Response to Planning application from Hertfordshire County Council (T and CP GDP Order 2015)

District ref: 6/2024/0389/HOUSE
HCC ref: WH/20608/2024
HCC received: 8 April 2024
Area manager: Manjinder Sehmi
Case officer: Geoffrey McMahon

14 Gorseway Hatfield AL10 9GS

Erection of a single storey rear/side extension, front porch and new vehicular hardstanding

GROUND FLOOR PLAN

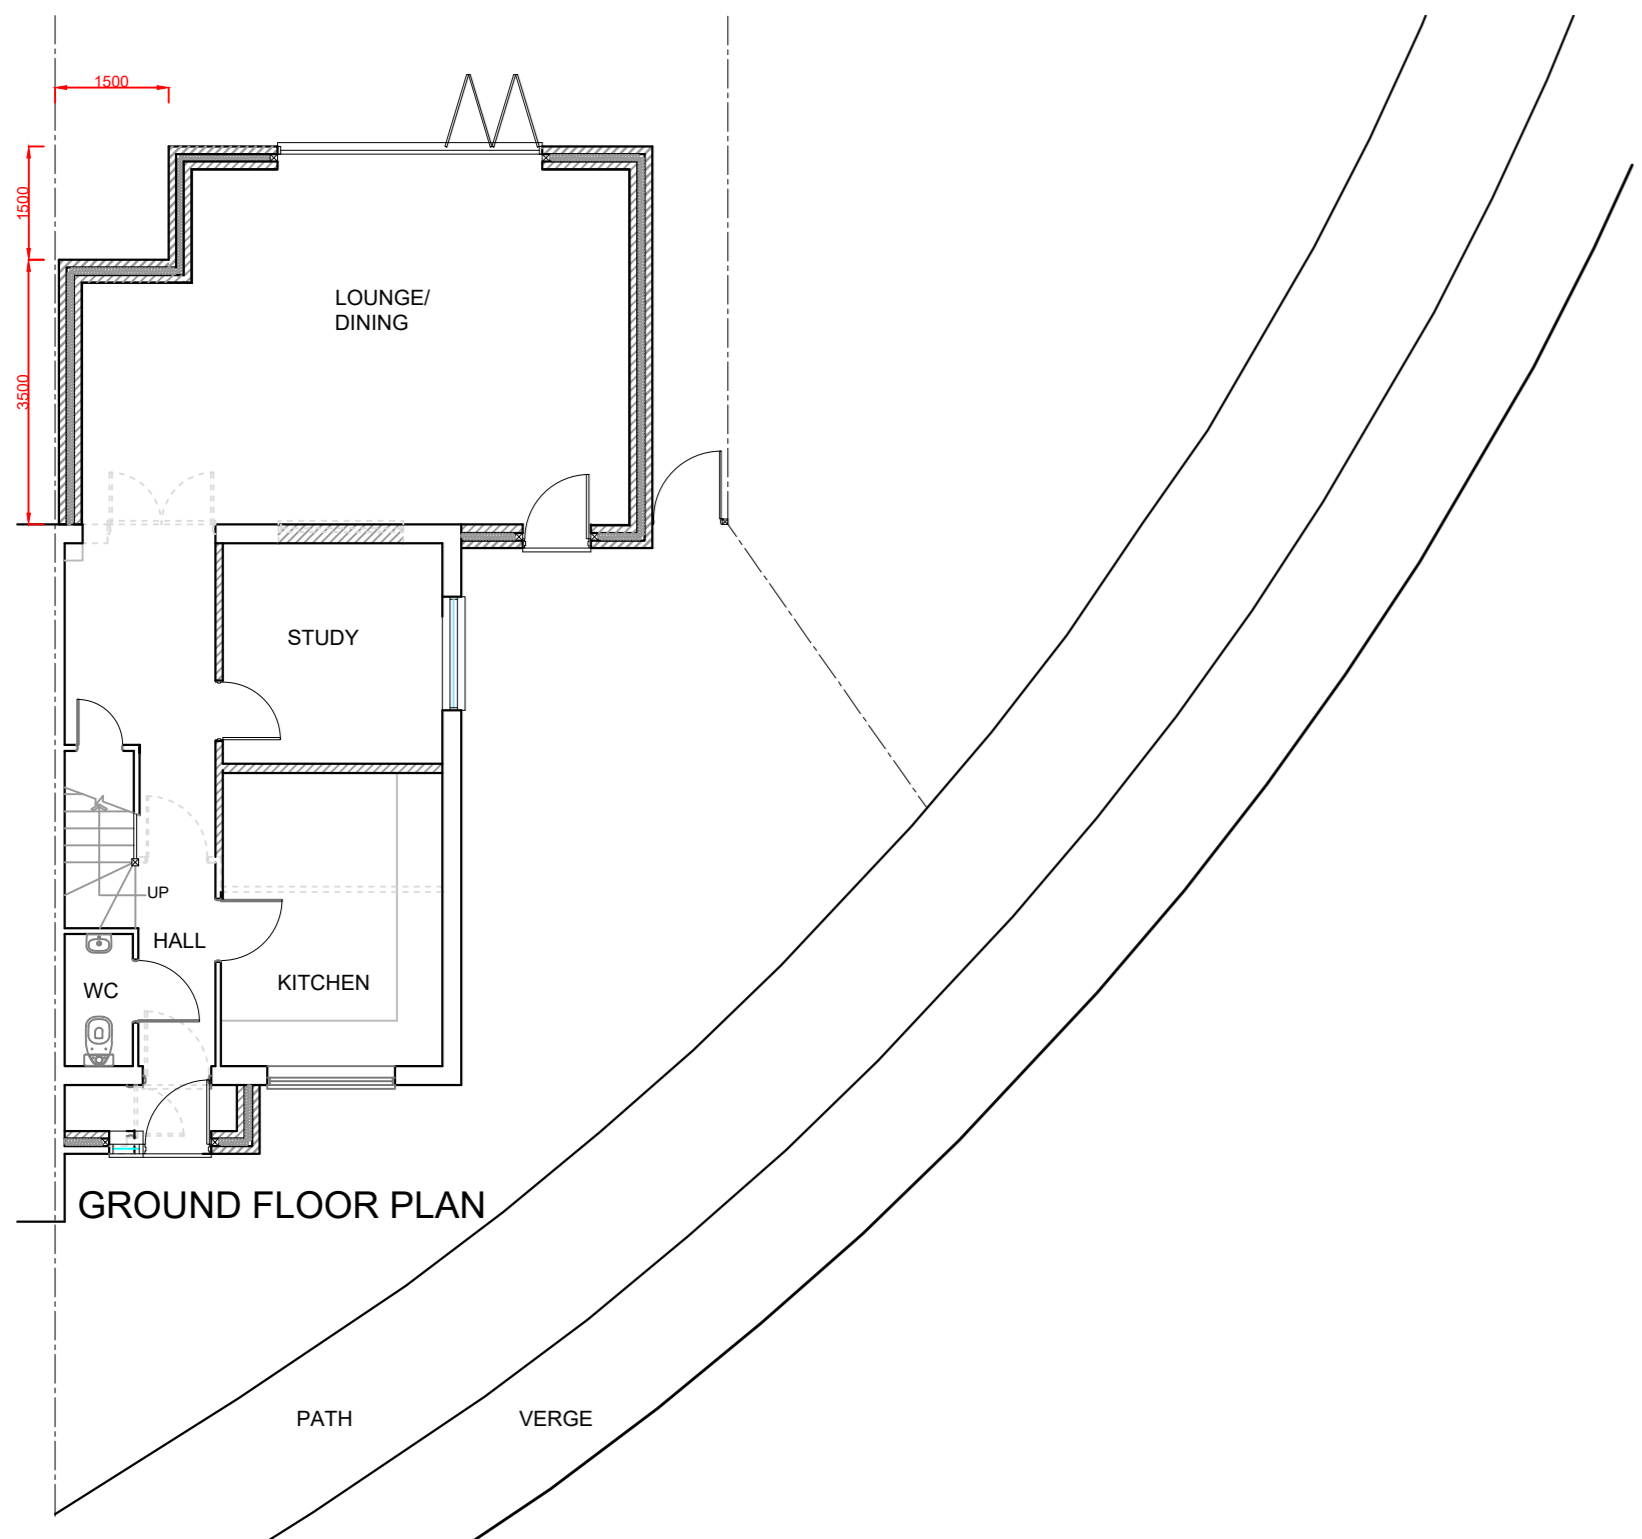
Insufficient information: the proposal for new vehicle hardstanding fails to supply adequate information relating to access, materials, drainage and visibility splays.

The current guidance for vehicle hardstanding and crossovers includes specific requirements for the minimum dimensions of a parking space, its relationship to the public highway (including the approach gradient) and the materials with which it is surfaced. Consideration should also be given to drainage, and visibility with and between drivers and pedestrians. Neither the Application Form nor the accompanying 'Plans and Elevations as Proposed' (Drawing No.5899-P01, rev.D) contains any information relating to these factors, rendering it impossible to make any determination with regard to the application from the Highway Authority's perspective.
